Charlotte Department of Transportation

Memorandum

Subject: Rezoning Petition 08-048: Located south of Old Mt. Holly Road, along the west side of Aqua Chem Drive

C1.0

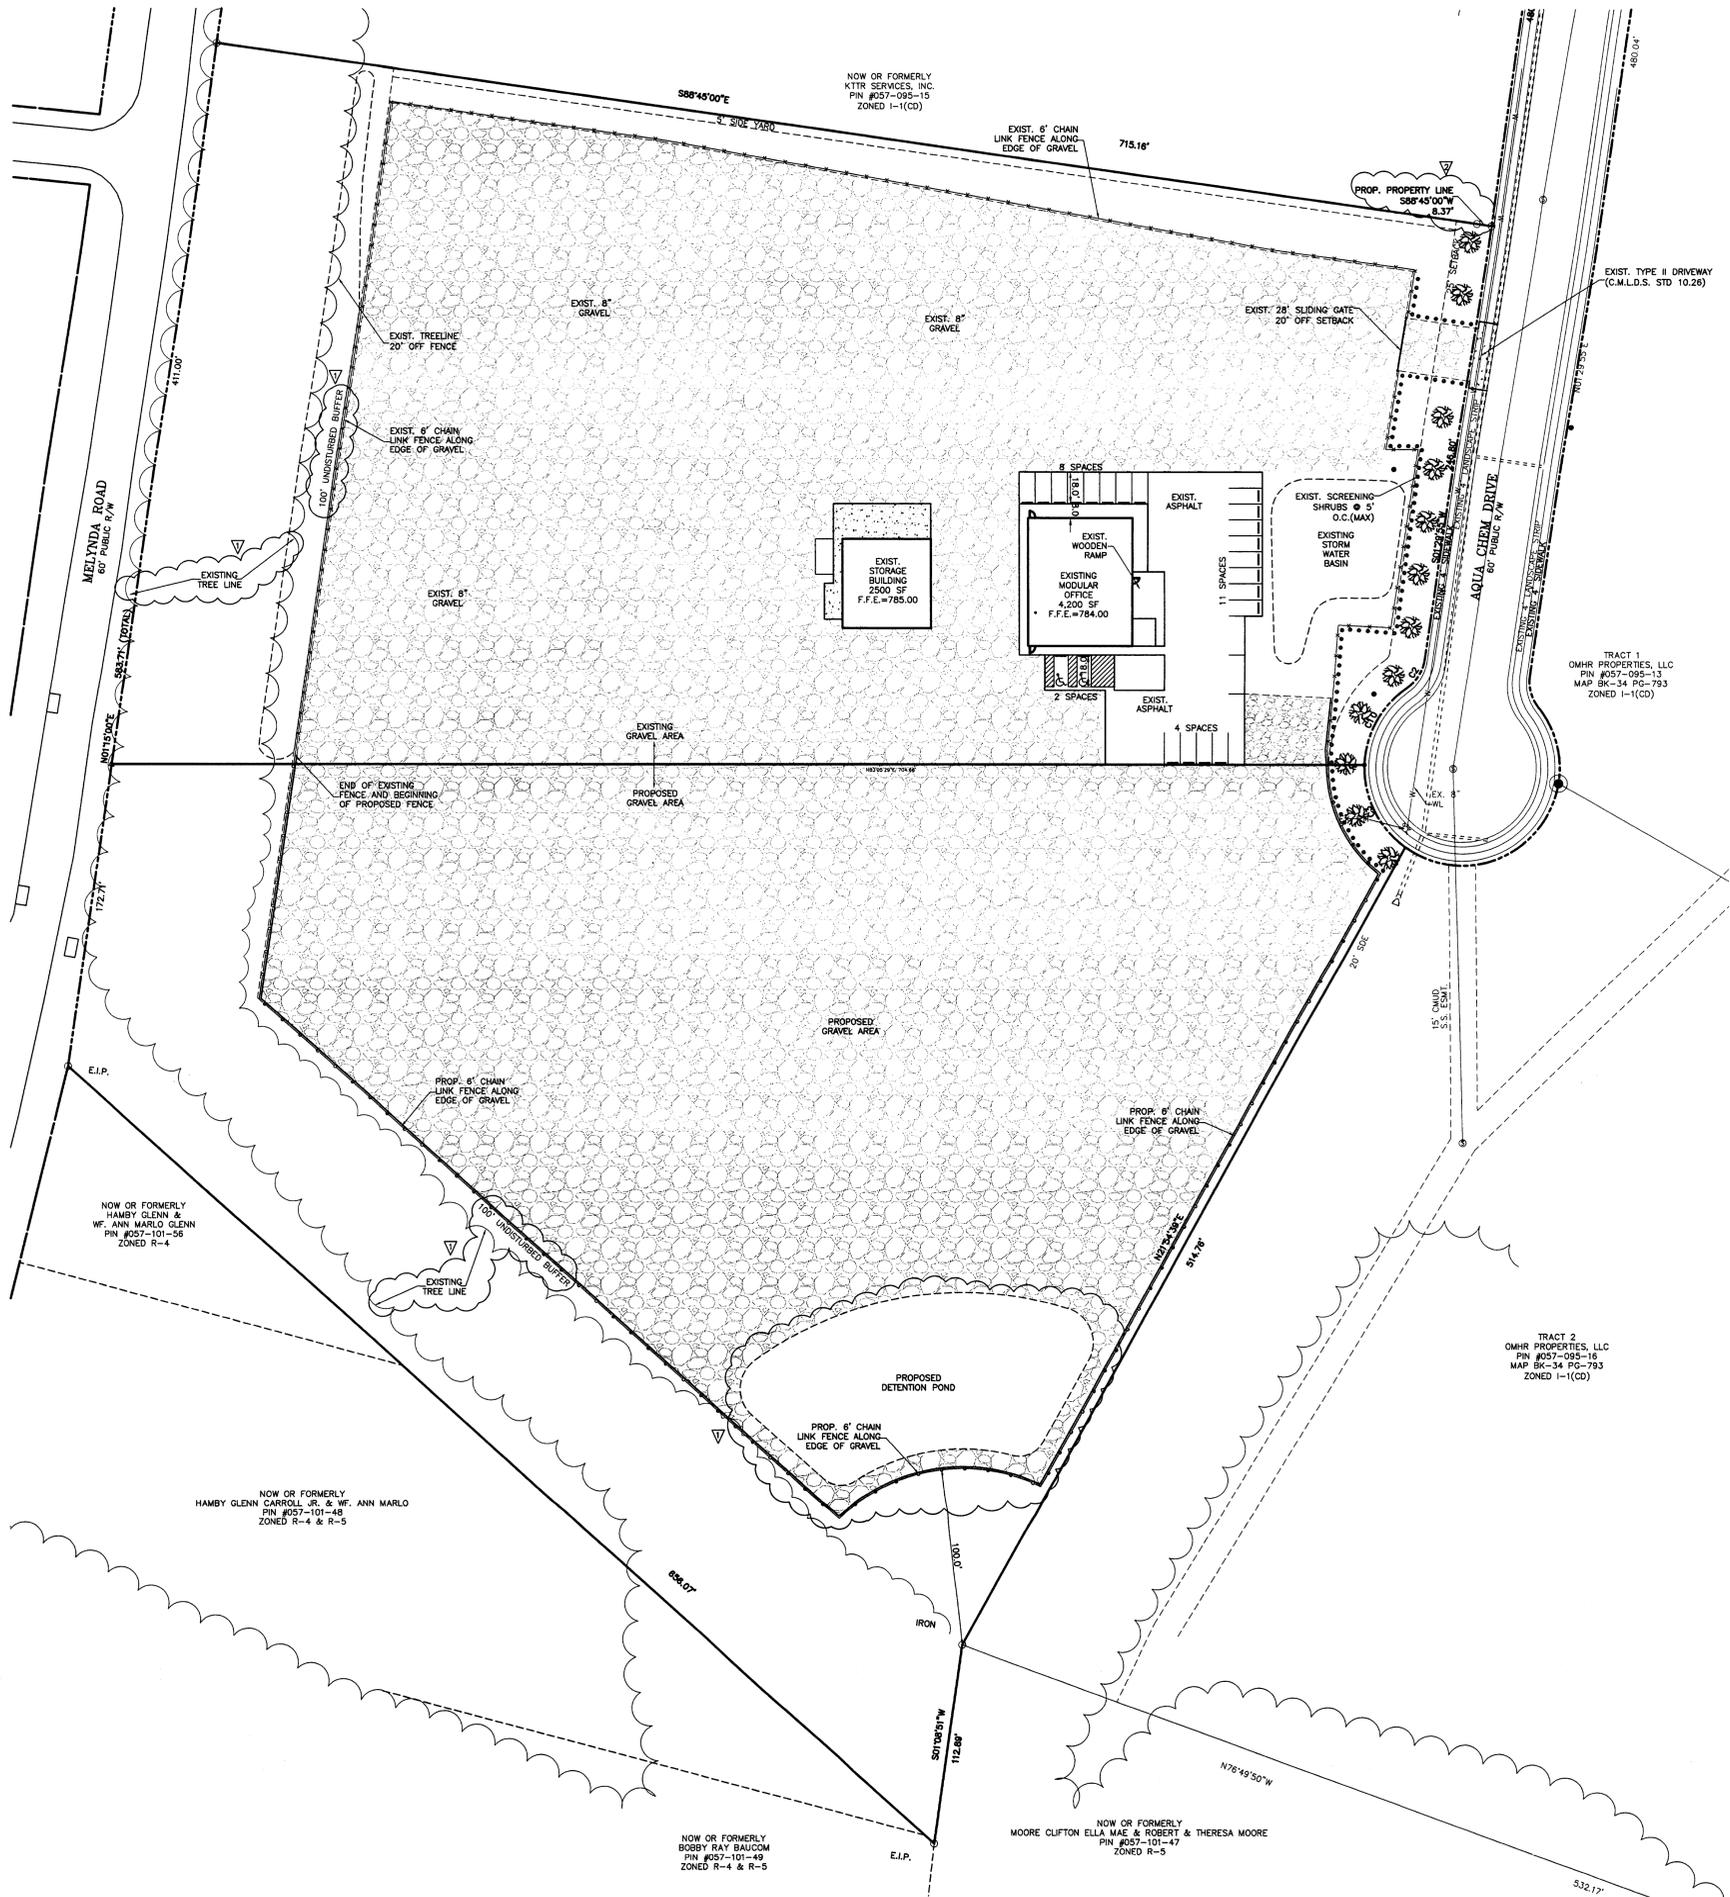
1. The proposed driveway to Aqua Chem Drive needs to be paved for a distance of 100 feet from the back-of-curb.
2. To eliminate the conflict of bumper overhang with pedestrians on sidewalks along parking areas, a 7-foot wide concrete sidewalk or a combination of a 5-foot sidewalk/2-foot planting strip needs to be provided from the front of the parking spaces. The CLDSM detail number 50.09B needs to be referenced for the 90 degree parking space design.

3. Along Melynda Road, the petitioner needs to provide new curb and gutter, an 8' planting strip and 5' sidewalk.
4. As shown on the site plan, there is an existing gate at the driveway entrance to Aqua Chem Drive. The gates must open and be recessed into the site a sufficient distance to store an entering vehicle without encroachment into the right-of-way or setback. This distance measured between the gates and the right-of-way is dependent on the length of the largest truck accessing the site and will be reviewed during the building/driveway permit process.

Adequate sight triangles must be reserved at the proposed driveway. Two 10' x 10' sight triangles are required for the entrance(s) to meet requirements. All proposed trees, berms, walls, fences, and/or identification signs must not interfere with sight distance at the entrance(s). Such items should be identified on the site plan.

- Dimension width of the existing and proposed driveways.
- New/reconstructed driveways must be drop curb ramp Type II driveways.
- Indicate the locations and widths of all adjacent and opposing driveways.
- Indicate typical parking module dimensions.
- Include a parking summary with figures for the numbers of parking spaces required and provided.
